**Symmetry Park, Oxford  
North - Junction 9, M40,  
Bicester**

**Landscape and Visual  
Impact Assessment -  
Review**

**Final report**

**1.2** This report sets out a review of the final submitted LVIA prepared by Environmental Dimension Partnership Ltd (EDP) as part of an Environmental Statement (ES) to accompany the planning application (22/01144/F). The review has been undertaken to ensure that the LVIA adheres to the Town and Country Planning (Environmental Impact Assessment) Regulations 2017 (the EIA Regulations). It comments specifically on the robustness of the LVIA in relation to current industry guidance – namely Guidelines for Landscape and Visual Impact Assessment, Third Edition (GLVIA3) – and provides requests for clarification where relevant (see Chapter 3 for a summary of clarification requests).

Detailed Landscape Proposals

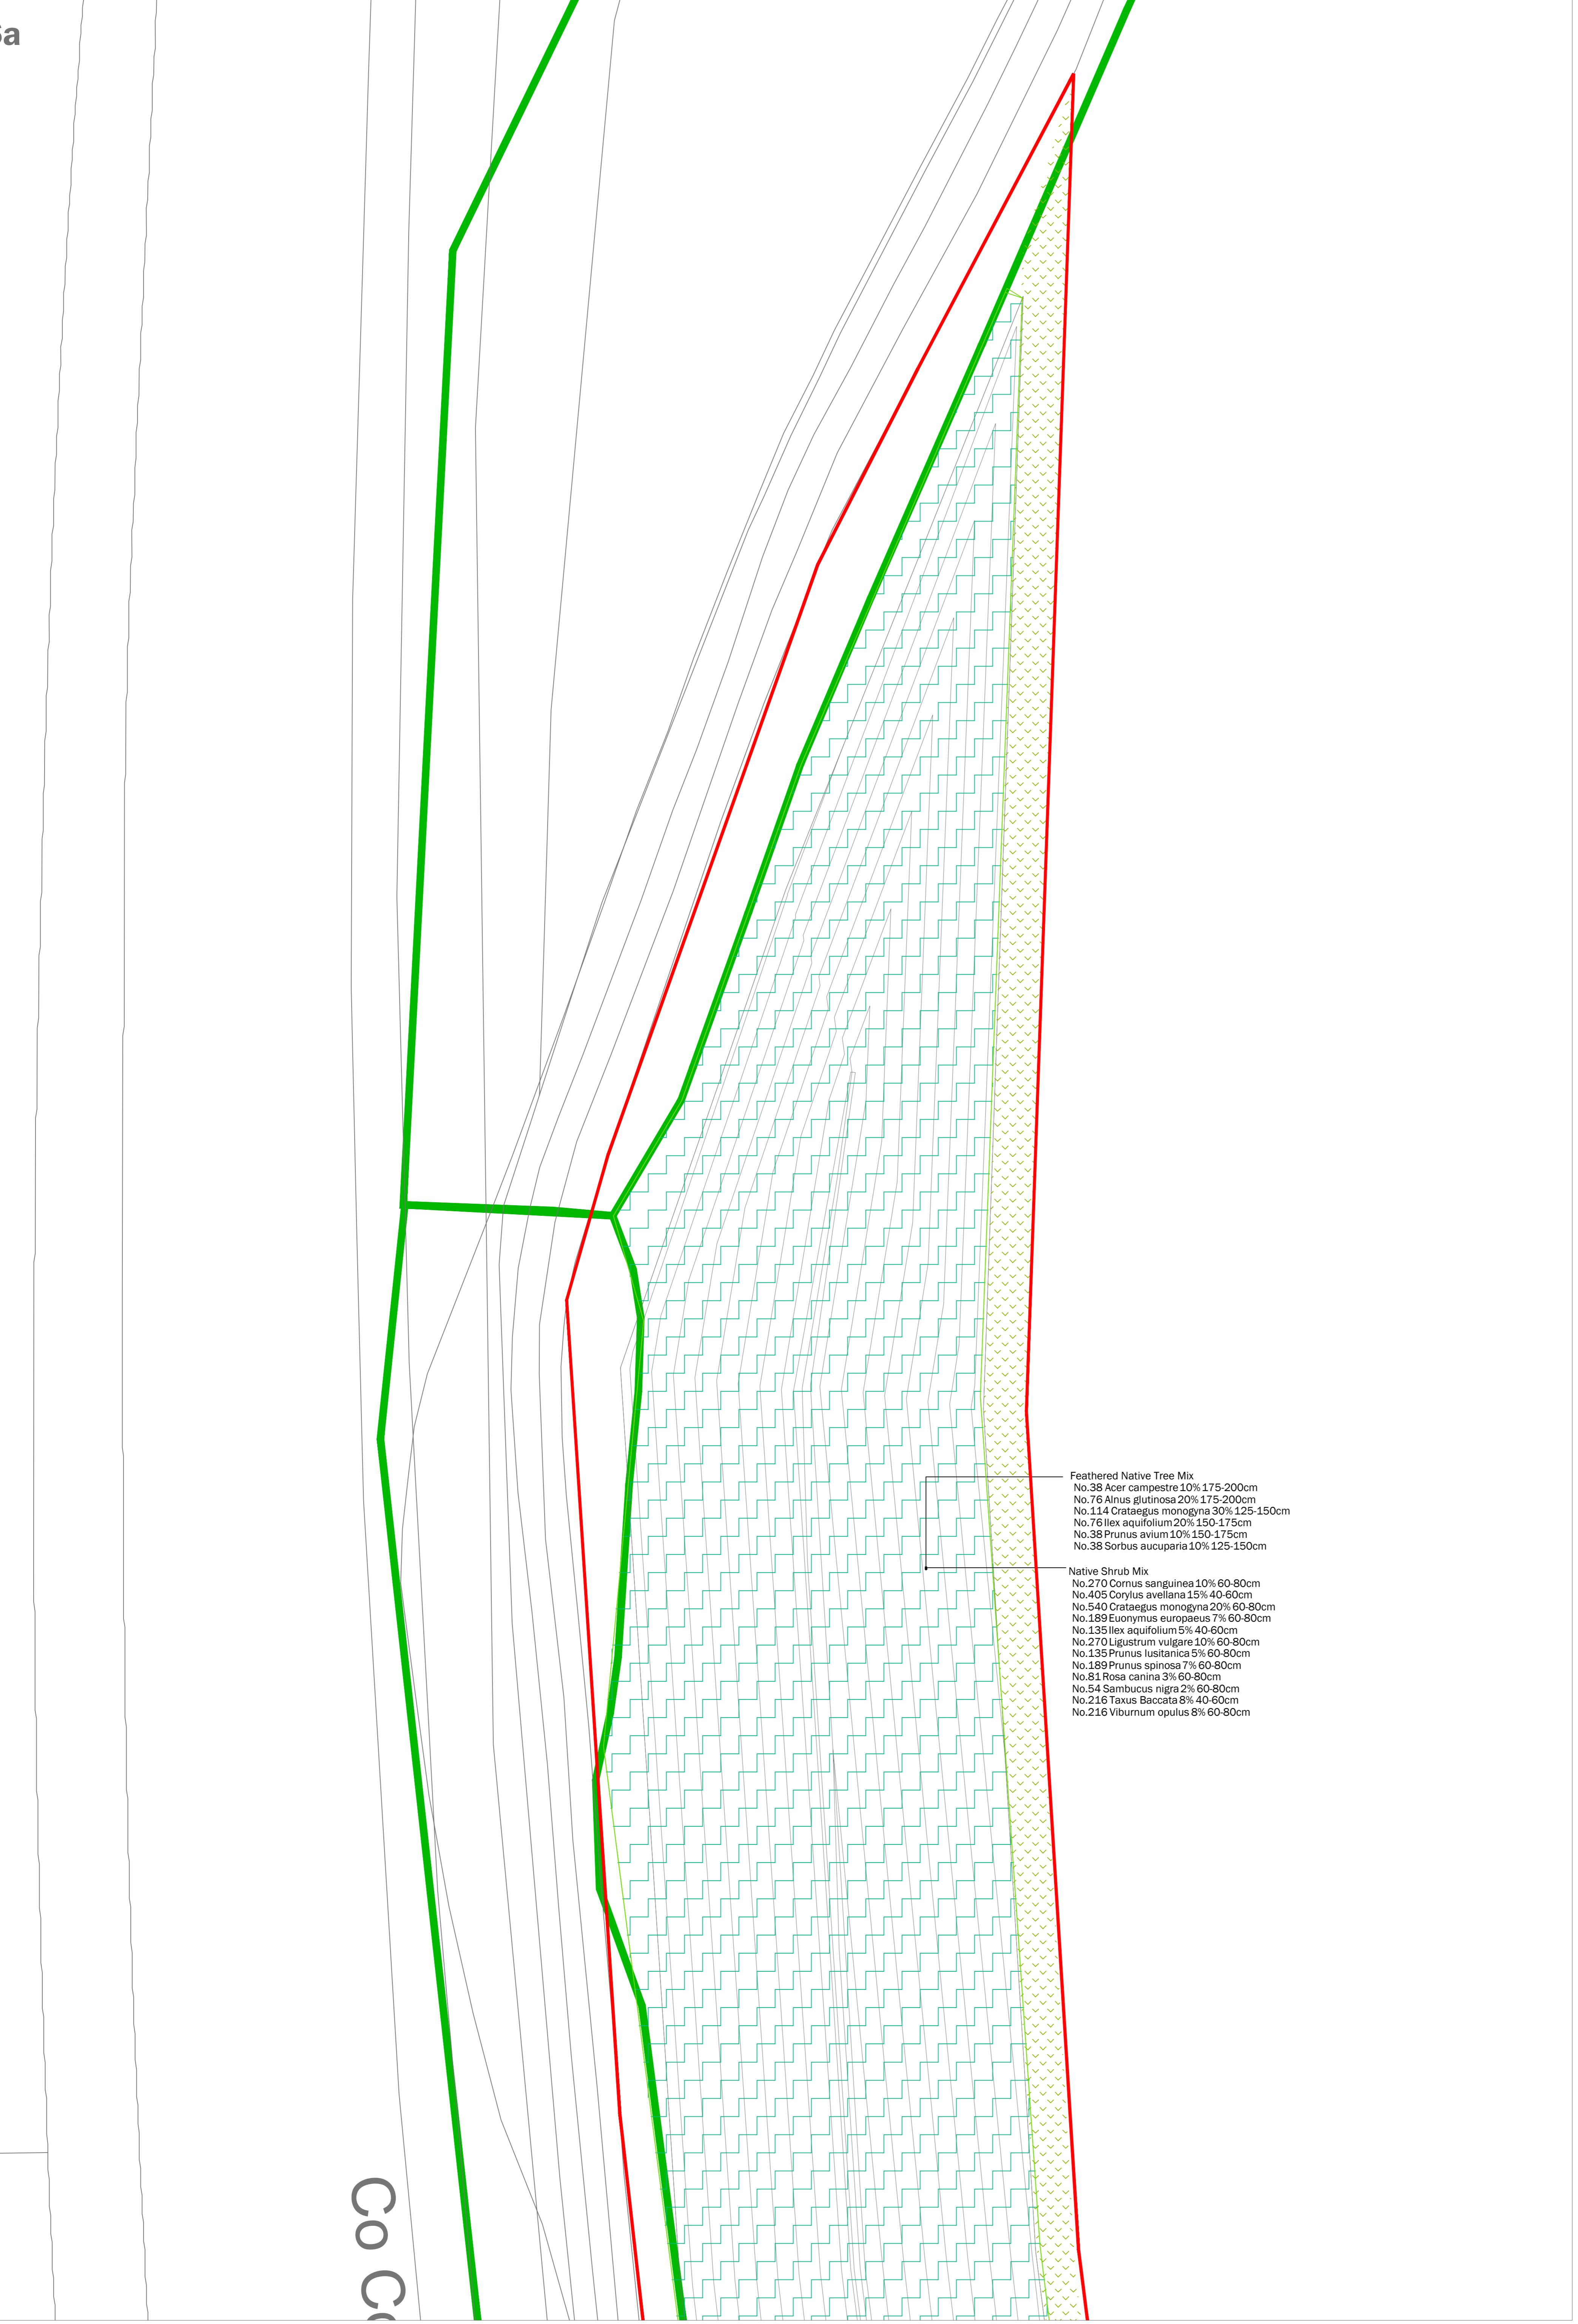
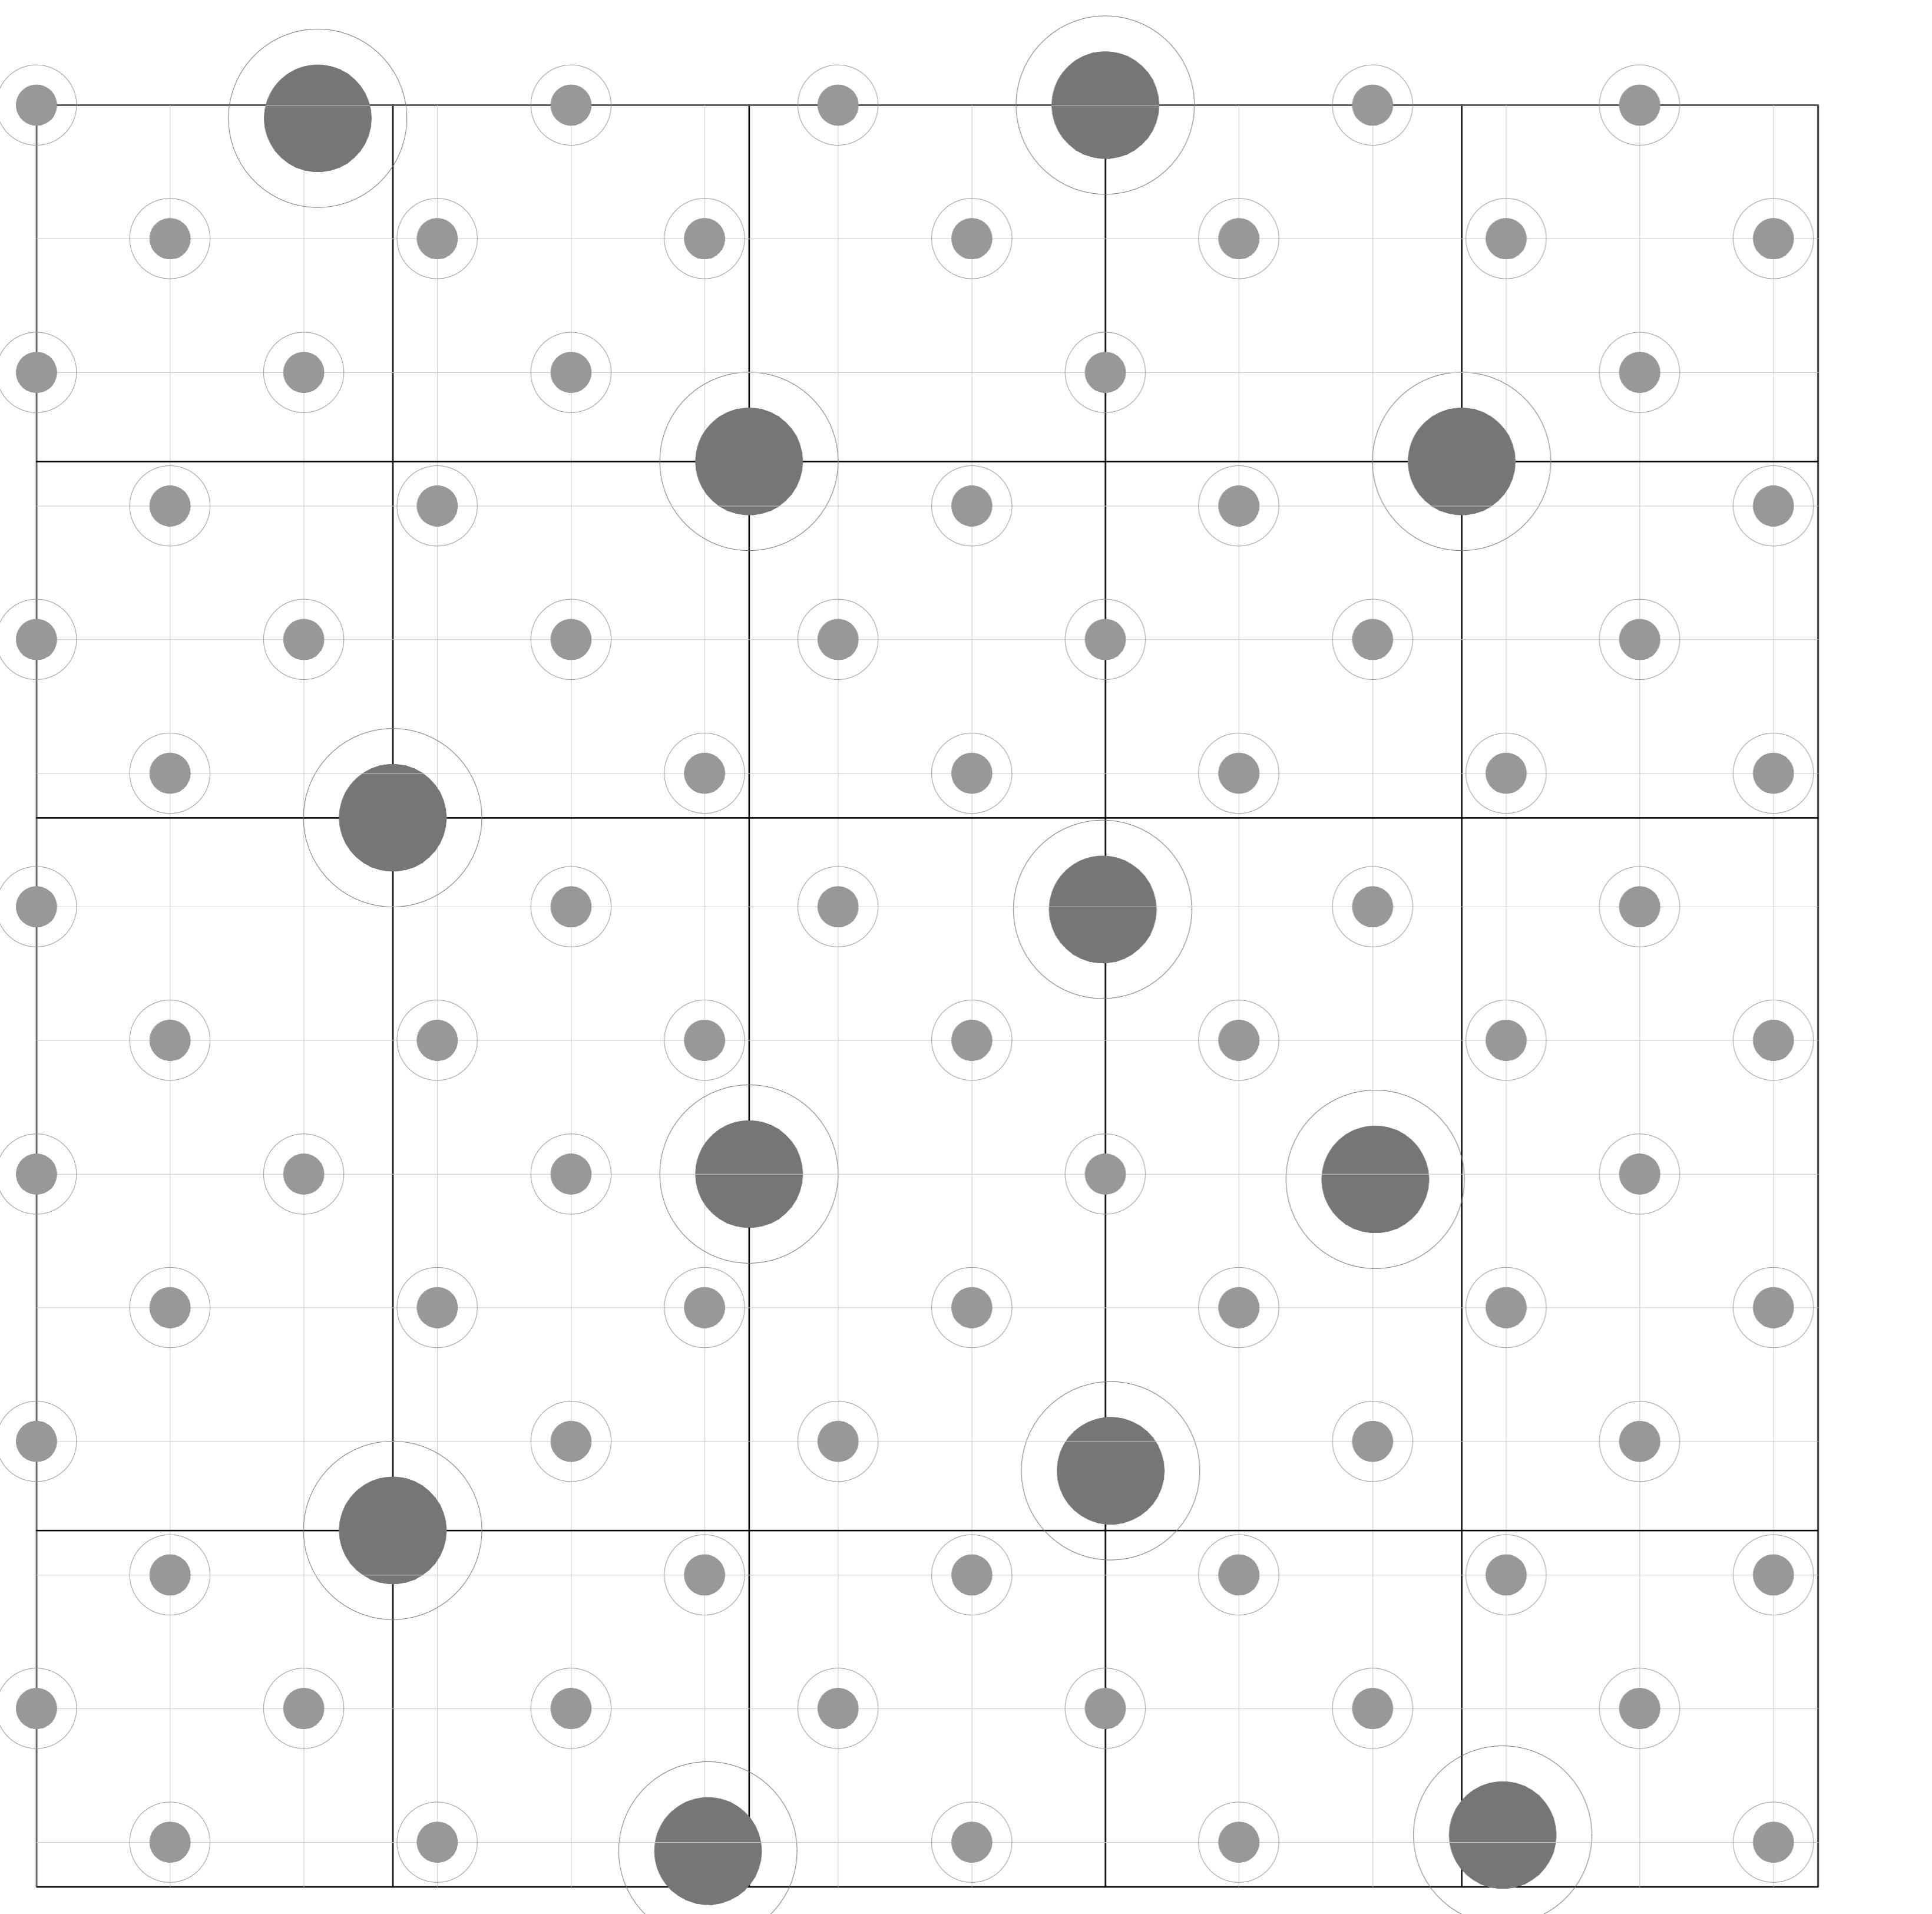
**2.42** The applicant should also comment on whether the bunds will be softened to appear ‘natural’ (the bunds shown on the detailed landscape proposals in Appendix 9.4 look very angular).

- Which vegetation will be in front of the development and which will be removed or behind the building for viewpoints 6 and 11.
- Whether the bunds will be softened to appear 'natural' (the bunds shown on the detailed landscape proposals in Appendix 9.4 look very 'angular').
